**RE: North Falls Offshore Windfarm – Representation by Harwich Haven Authority:
Navigational Safety and Pilotage in the Sunk Area**

Harwich Haven Authority (HHA), as the Statutory Harbour Authority and the Competent Harbour Authority for pilotage into and out of the Harwich Haven and surrounding areas, submits this representation to the examination of the North Falls Offshore Windfarm Development Consent Order (DCO) application.

Figure 2.1 Overview of AOI (including Concurrent Working Areas)

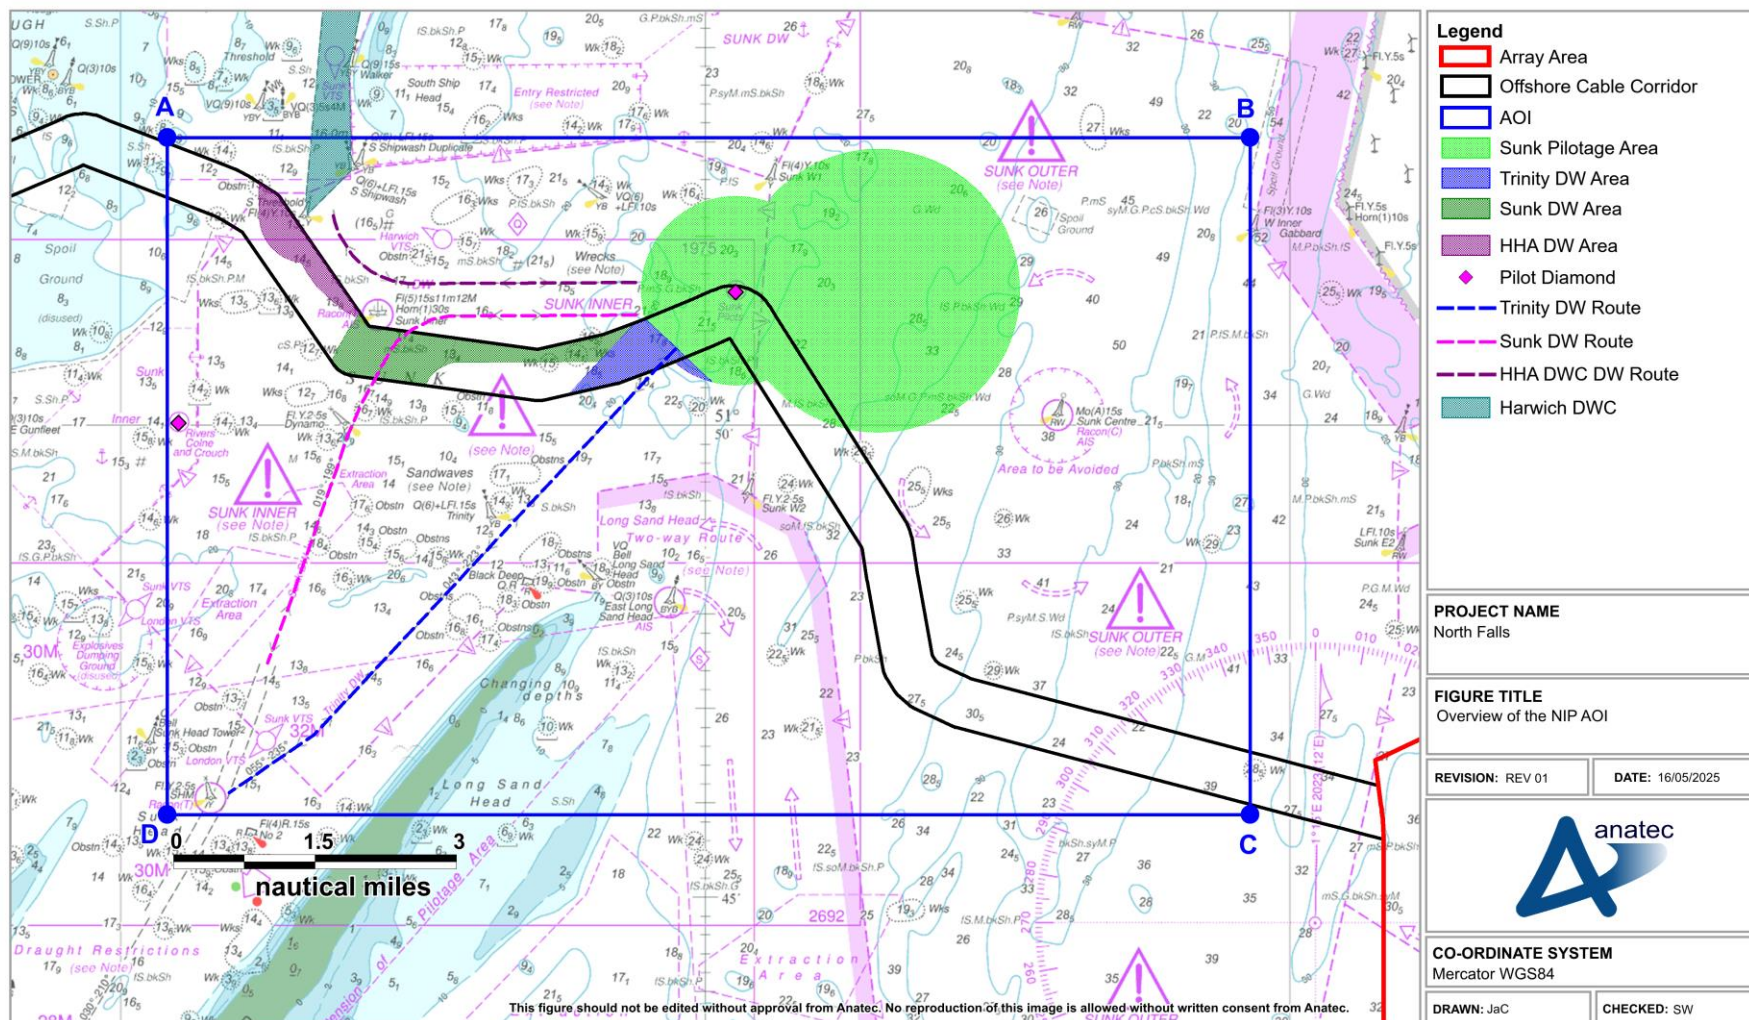
However, we maintain the position that controls over concurrent construction and maintenance Restricted Ability to Manoeuvre (RAM) operations in the Sunk area must be explicitly secured within the DCO itself, rather than being embedded solely within associated certified documentation. From our perspective, this offers a more transparent and legally robust mechanism to manage a safety-critical issue.

Recommends that no infrastructure, safety zones, project works, or RAM activity impinges on operational sea room critical to pilotage.
